REPORT UPDATE

Application No: FG/198/16/PL

Recommendation Report for Planning Permission

PROPOSAL: Demolition of existing house with erection of 2 storey building comprising of 8No. residential 2 bedroom flats & associated external works

FRONT ELEVATION

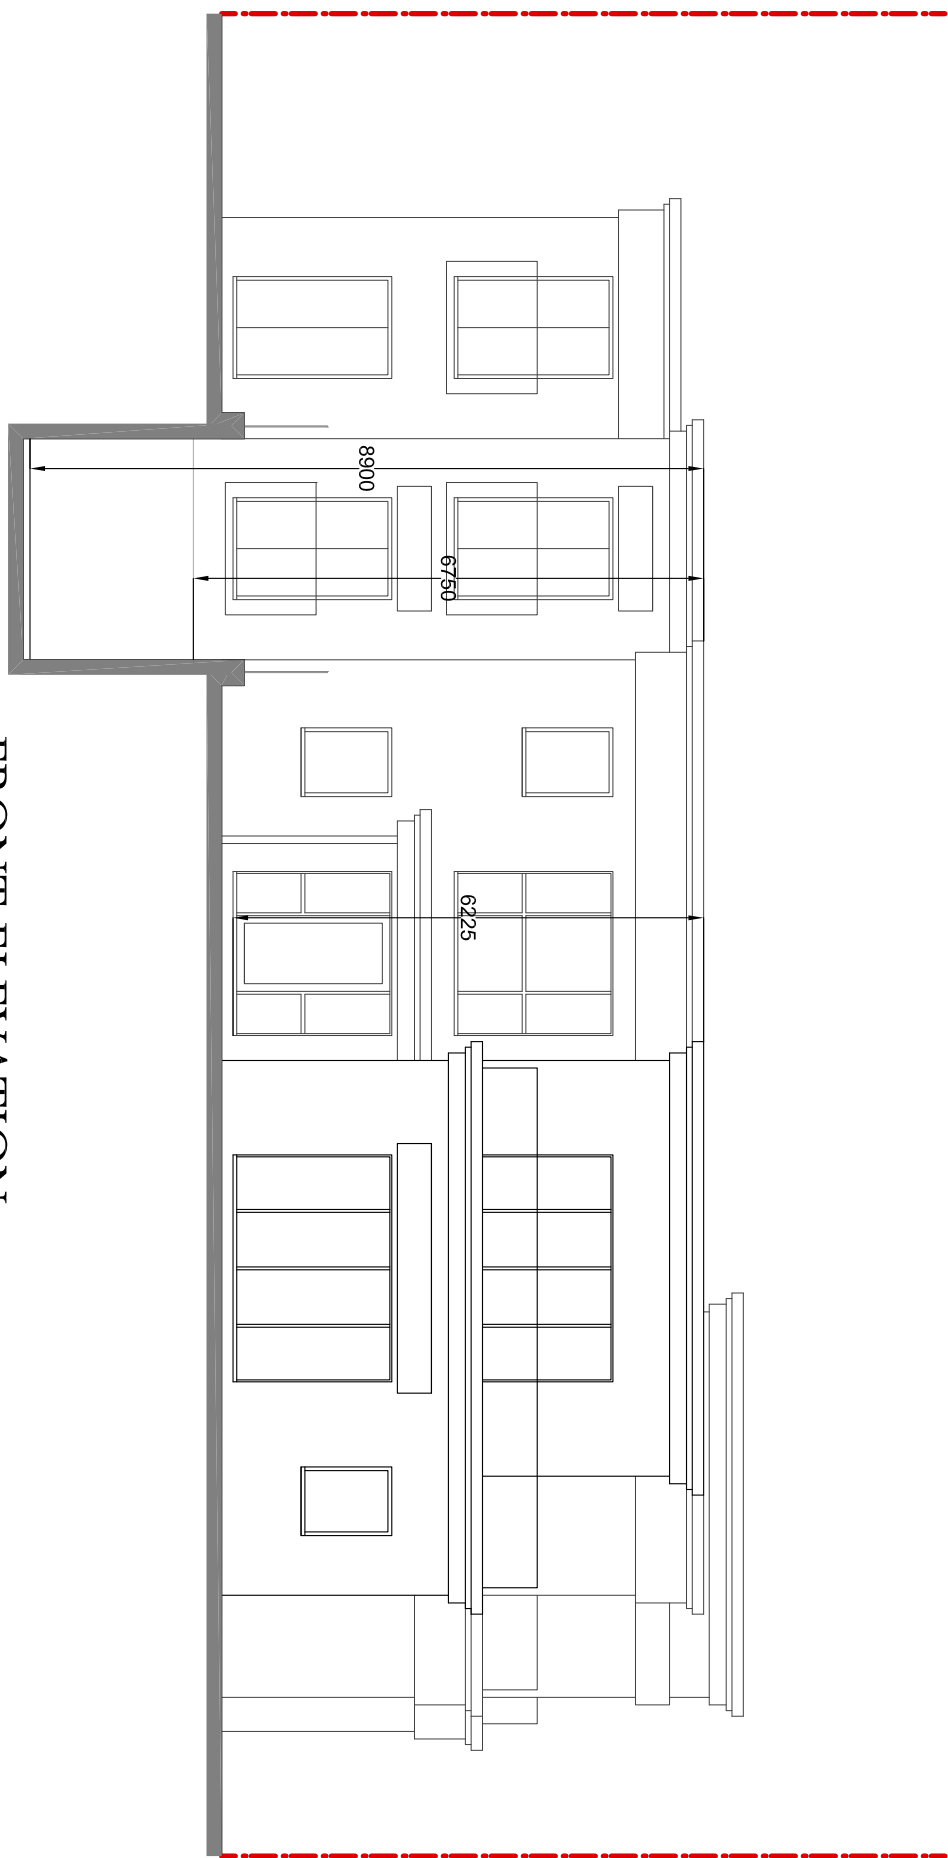
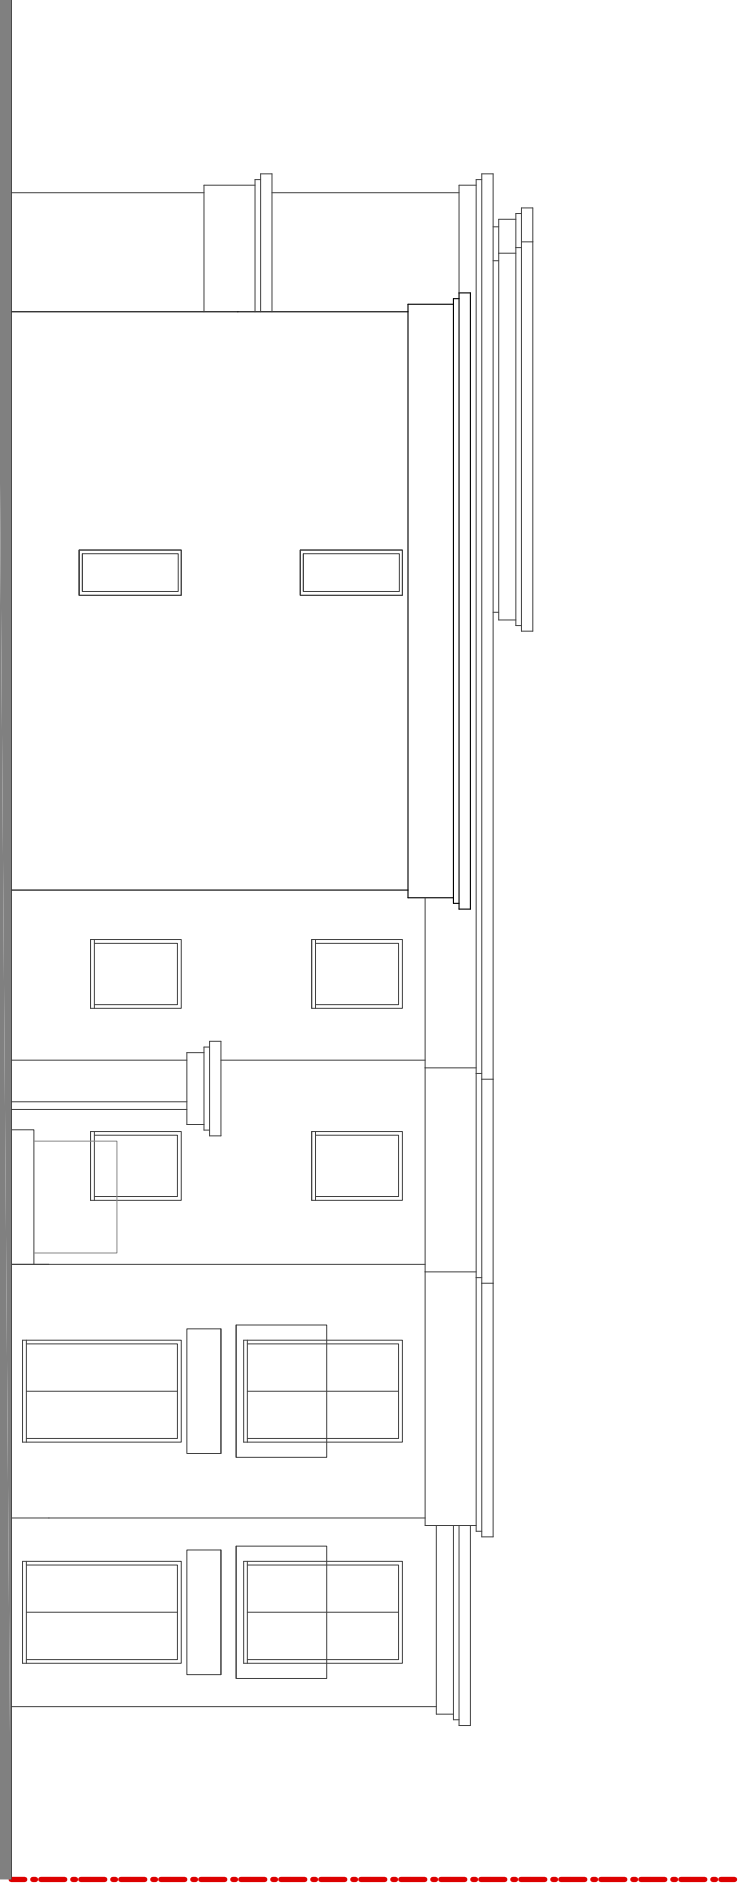
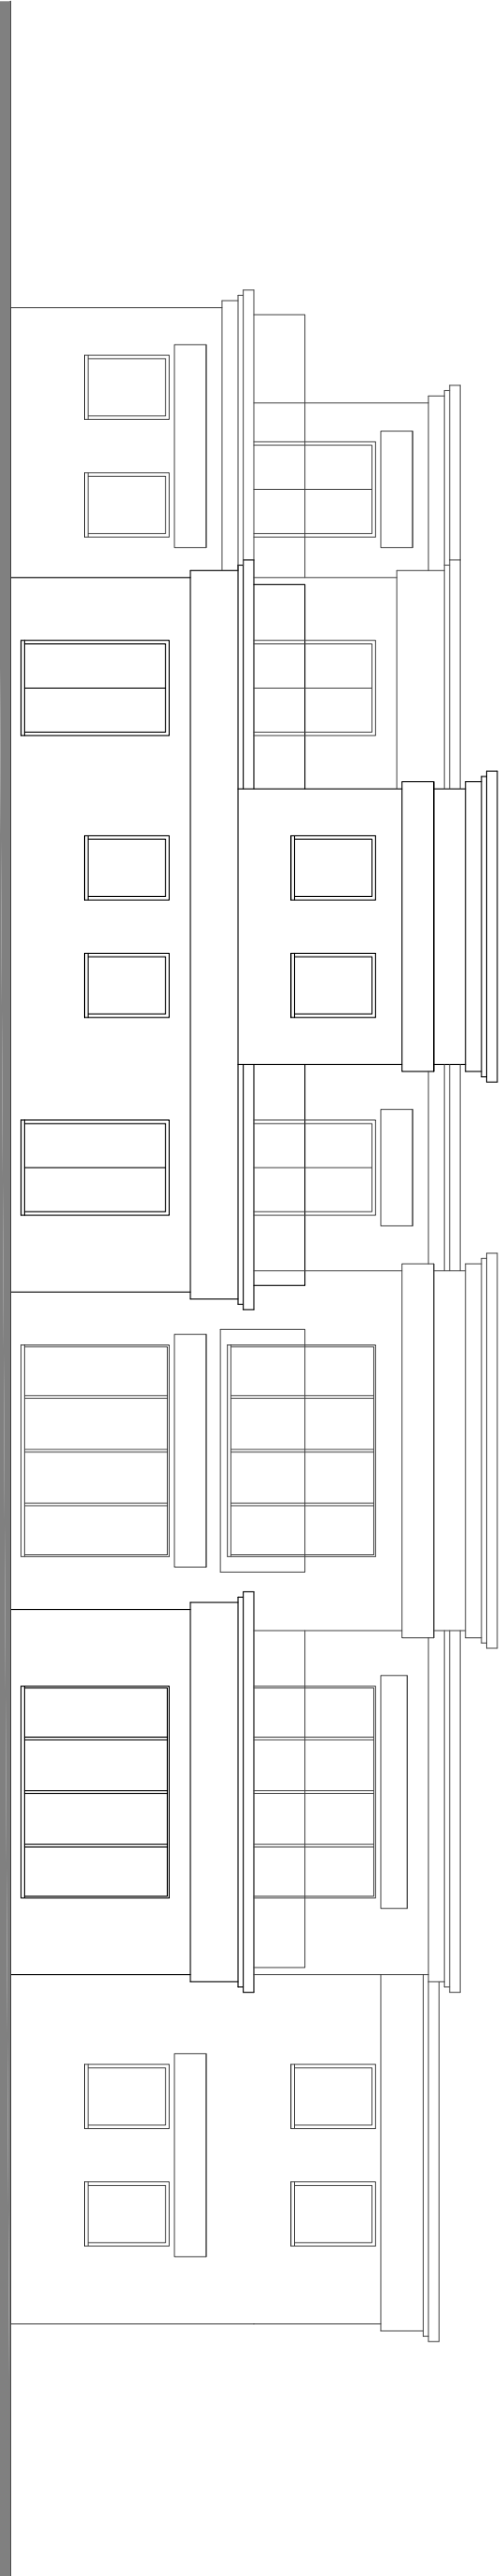
- Height of proposed block and Inaccuracy of plans

The height of the proposed block has raised 20 cm from the plans first submitted as shown on PL005 Rev J dated March 2017 due to the inclusion of the underground car park. The minor error (10cm) occurred in the response to Mr. Gann was due to line thickness on the plans.
